Narrabri Coal Seam Gas Utilisation Project

PEL 238, Gunnedah Basin

Response to Submissions to the Environmental Assessment

August 2008

Figure 5.13
PREDICTED NOISE LEVELS
AROUND WILGA PARK
POWER STATION

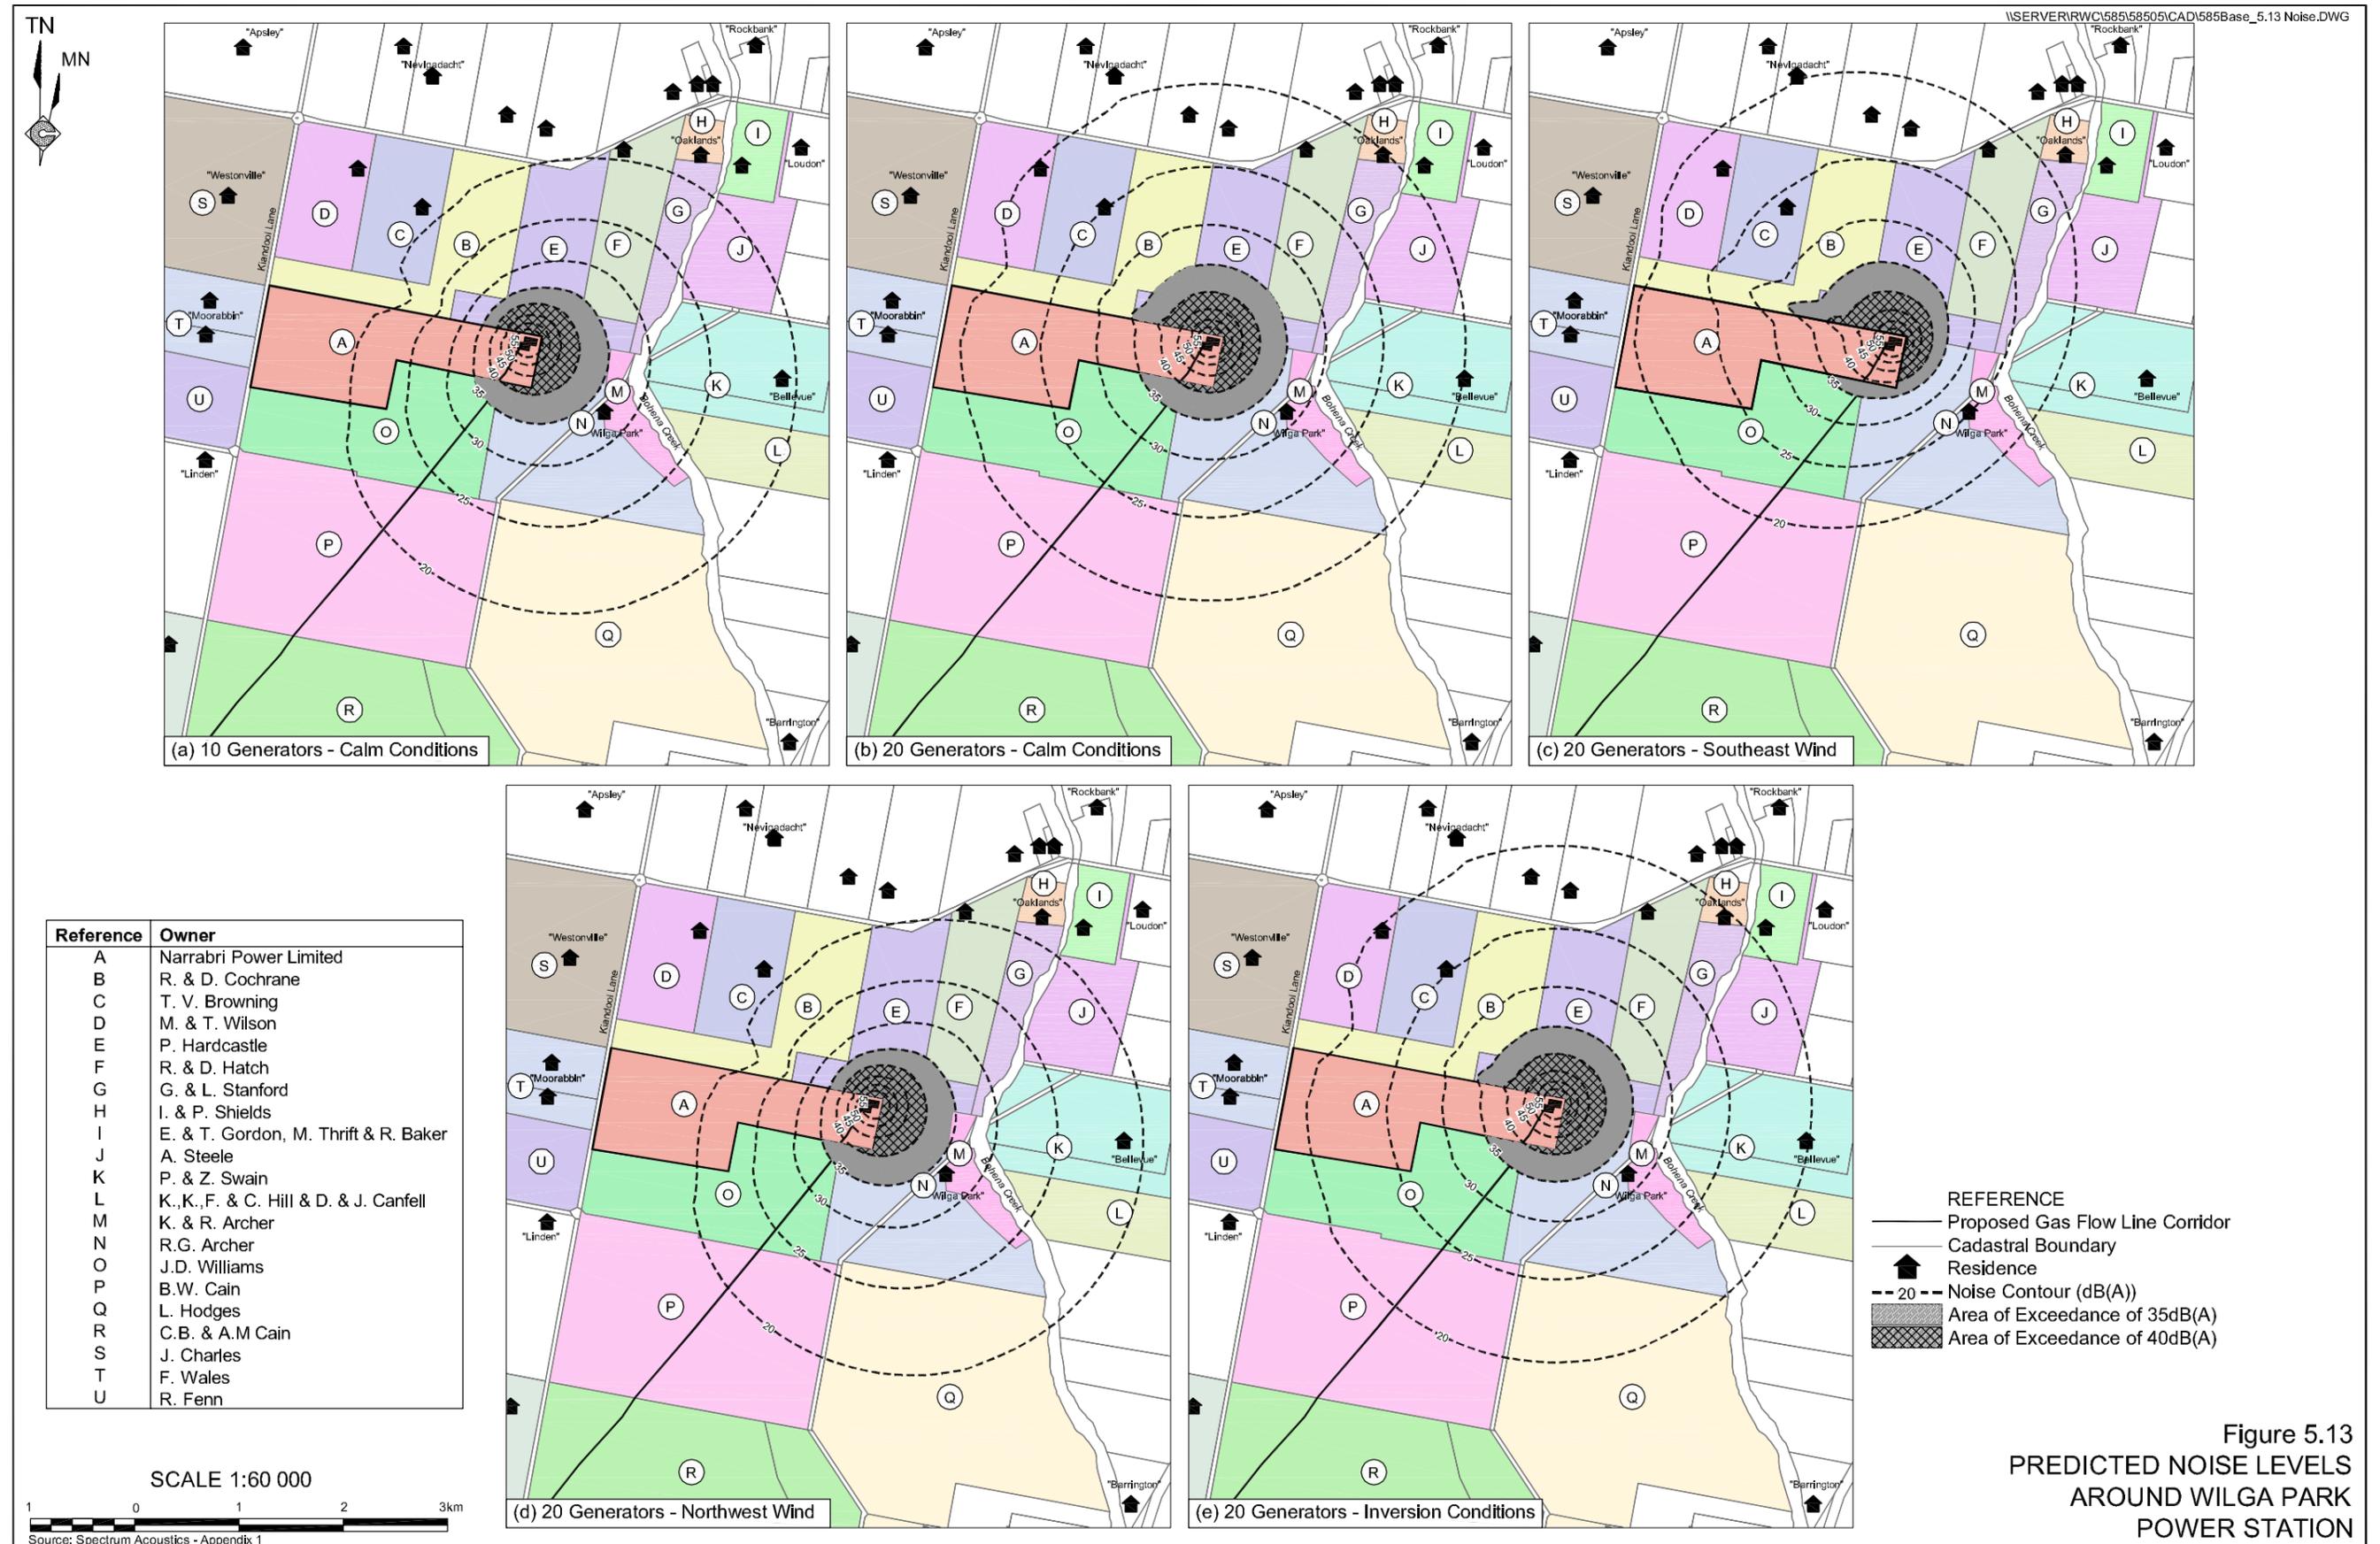
No additional information needed, however, DECC notes potential for future land use conflict if residences built within the predicted 35dB(A) contour.

The issue of sensitive receptors around the expanded power station site and the area impacted by exceedances of the 35dB(A) $L_{eq(15 \text{ minute})}$ noise level whilst the power station is operating at full (40MW) capacity has been discussed at length in Section 5.9.4.2 of the EA.

ESG agrees with Dr Neil Pennington's recommendation that operational noise monitoring should be conducted (page 6-19 of the Noise Assessment to clearly identify the area around the Wilga Park Power Station where the 35dB(A) criteria cannot be satisfied, ie. effectively validating the zones depicted on Figure 5.13 in the EA. This monitoring is committed to in Action 10.8 in the Final Statement of Commitments. In reality, the area of land beyond the property owned by Narrabri Power Limited within the 35dB(A) contours on Figure 5.13 is comparatively small and at the "rear" of the adjoining properties where it is unlikely residences would be constructed. The pattern of residential building in this area typically shows residences between the section of the property fronting the road and the centre of the property.
